Last comment not addressed.
Please include Colorado Springs Utilities easement terms and conditions statement.

THE TRAILS AT ASPEN RIDGE FILING NO.5
A SUBDIVISION OF TRACT H OF THE TRAILS AT ASPEN RIDGE FILING NO.3 LOCATED IN THE WEST 1/2 OF SECTION 9,
TOWNSHIP 15 SOUTH, RANGE 65 WEST OF THE 6TH P.M. EL PASO COUNTY, COLORADO
SHEET 1 OF 3

THE TRAILS AT ASPEN RIDGE FILING NO.5

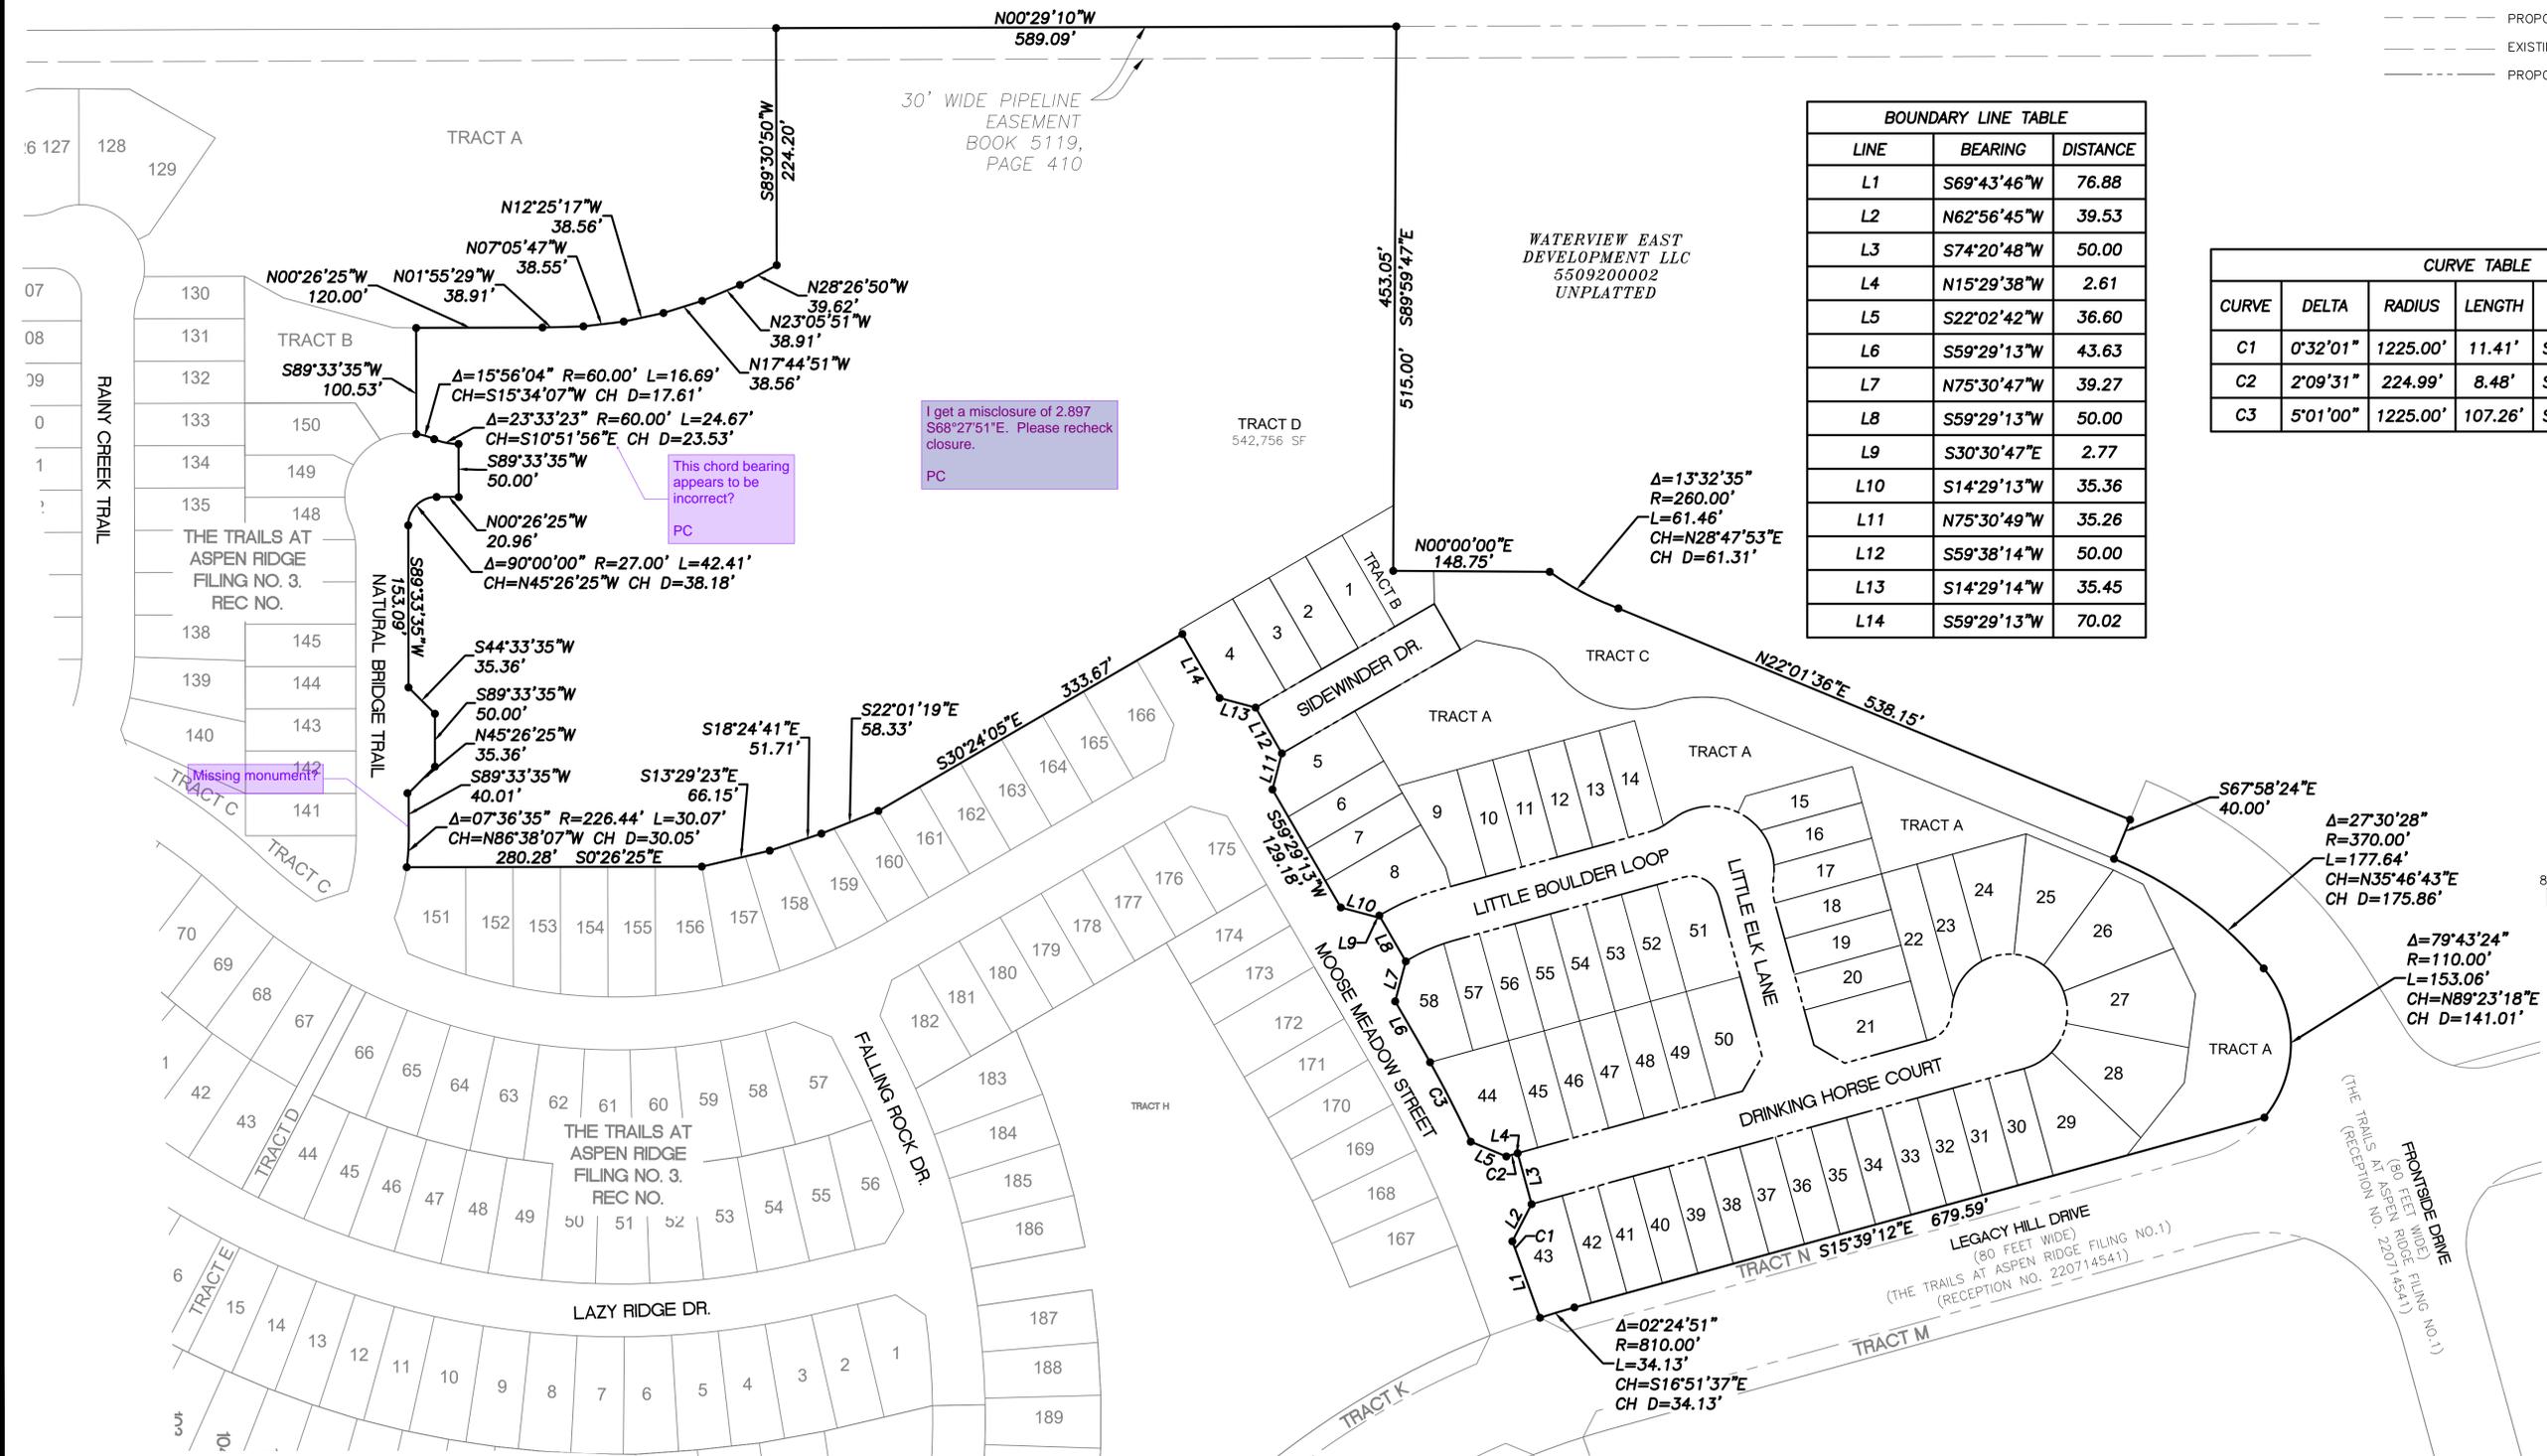
Missing Curve Table or
C1 and C2 are switched
comparing with previous
page.
